From: Lisa Coney on behalf of Planning
Sent: 02 December 2013 10:41
To: Karen Garner
Subject: FW: Correction: Planning Application WSCC/096/13/F- Waste Treatment Facility

From: Nat Slade
Sent: 13 December 2013 11:56
To: Peter Cleveland
Cc: Graham Evans
Subject: WSCC/096/13/F

From: Charlotte Hardy
Sent: 18 December 2013 10:52
To: Peter Cleveland
Subject: Graddon application - F/19/13

Figure 1: Plan Indicating Extent of Proposed Noise Barrier

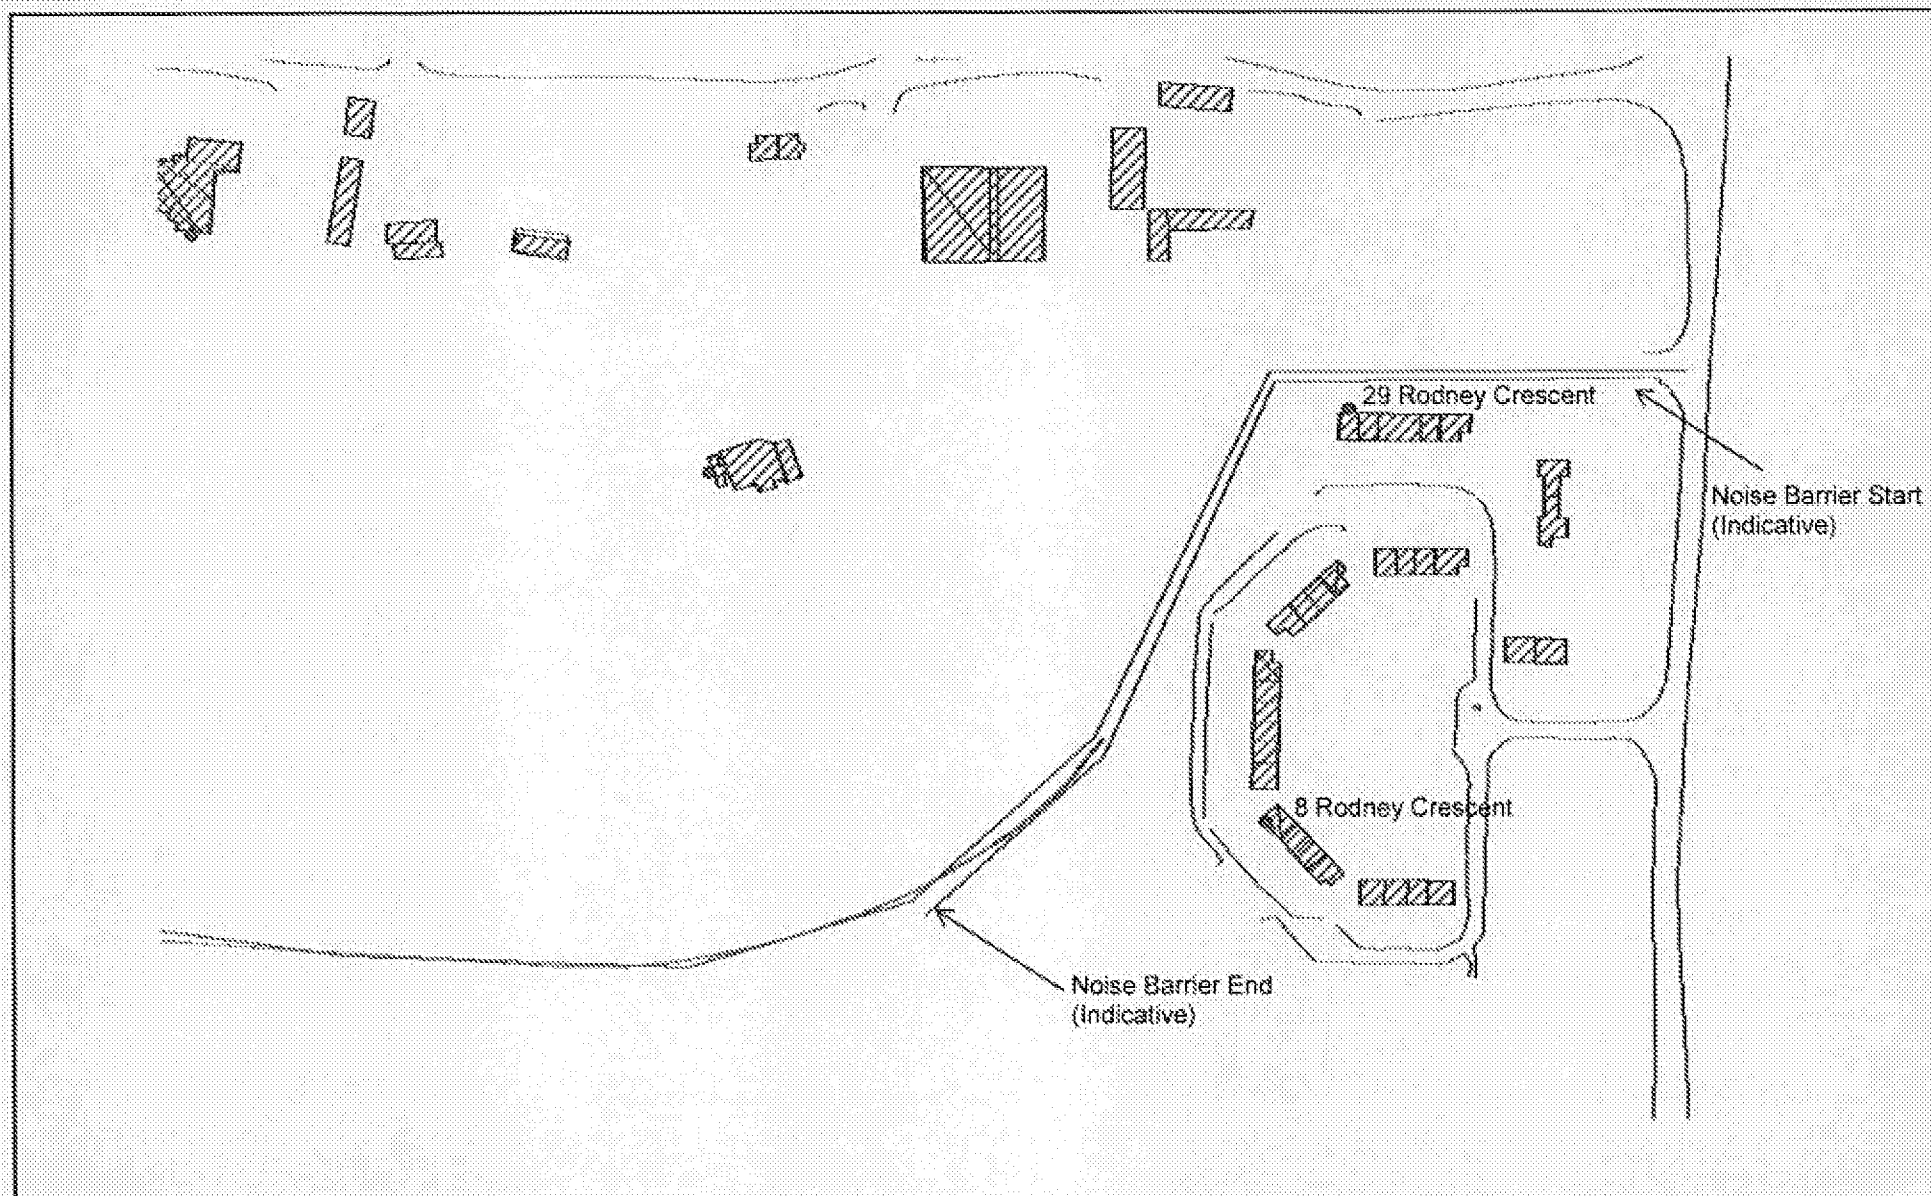
The way that the noise modelling results have been presented, using time averaged sound pressure levels, does not fully represent the disturbance that would be caused from movements of HGVs along the access roads during the daytime. HGV movements are short duration "noise events", but loud and disturbing. This is not fully recognised when reporting results using a time averaged figure. The noise levels and character of these short duration events immediately to the rear of residences has not been fully recognised in the Environmental Statement.

The noise from HGVs or other vehicle movements on the site access roads during the night does not appear to have been modelled at all. The report has not established if the continuous operation of the waste treatment process would necessitate night time movements of HGVs on and off the site, nor if other vehicles would be needed to load hoppers etc during the night, nor has it addressed the impact of these relatively short duration, but potentially disturbing noises. Both access roads pass immediately to the rear of residential premises at Rodney Crescent, Ford to the East, and a number of cul de sacs off Rollaston Park, Yapton, to the West. Further information on the

proposed night time, noise generating activities is needed. Alternatively, I recommend that the County Council by way of conditions prohibit movement of vehicles on the site, other than cars, after 1900 and before 0730.
